**WELWYN HATFIELD BOROUGH COUNCIL
EXECUTIVE DIRECTOR - PLANNING, PUBLIC PROTECTION AND GOVERNANCE**

DELEGATED APPLICATION

Application No: 6/2022/1649/EM
Location: 159 Parkway Welwyn Garden City AL8 6JA
Proposal: Installation of three rear rooflights to facilitate the conversion of the loft to habitable space
Officer: Mr James Homer

Recommendation: Granted

**7 Proposed Rear Elevation**  
1 : 100

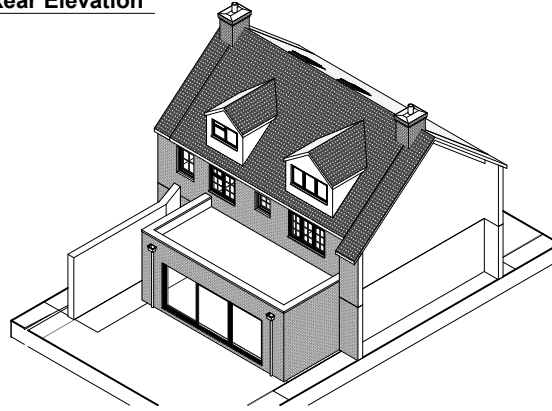
responses	
Consultee responses	No comments received.
Relevant Policies	
<input checked="" type="checkbox"/> EM1 <input type="checkbox"/> EM2 <input type="checkbox"/> EM3 Others	
Considerations	
Design (form, size, scale, siting) and Character (impact upon amenities and values of Garden City)	<p>Policy EM1 of the Estate Management Scheme states that extensions and alterations to existing properties will only be allowed if they are in keeping with the design, appearance, materials and architectural detailing used in the existing building and do not have a detrimental impact on the amenities and values of the surrounding area or the residential amenity of adjoining occupiers.</p> <p>The application proposes to install three roof lights within the rear roof slope of the building. Within the Estate Management Scheme area, roof lights should not affect the overall composition of the building or roofscape through their sensitive siting and should be positioned toward the rear of a property and not unduly visible from a public vantage point. It is recommended that roof lights are low-profile and recessed on sloped roofs.</p> <p>The proposed roof lights would not affect the overall composition of the building and, although glimpsed views may be seen from surrounding streets, the character of the property or area would not be unduly harmed.</p>

Impact on neighbours	The proposed roof lights would not result in a loss of light or outlook nor unduly impact upon the privacy of neighbouring homes.
Landscaping issues (incl. hardstandings)	None proposed.
Any other considerations	None.
Conclusion	
The proposed roof lights would not result in a detrimental impact upon the appearance of the property, the character of the area or the amenity of neighbouring homes. The application therefore, complies with Policy EM1 of the Estate Management Scheme.
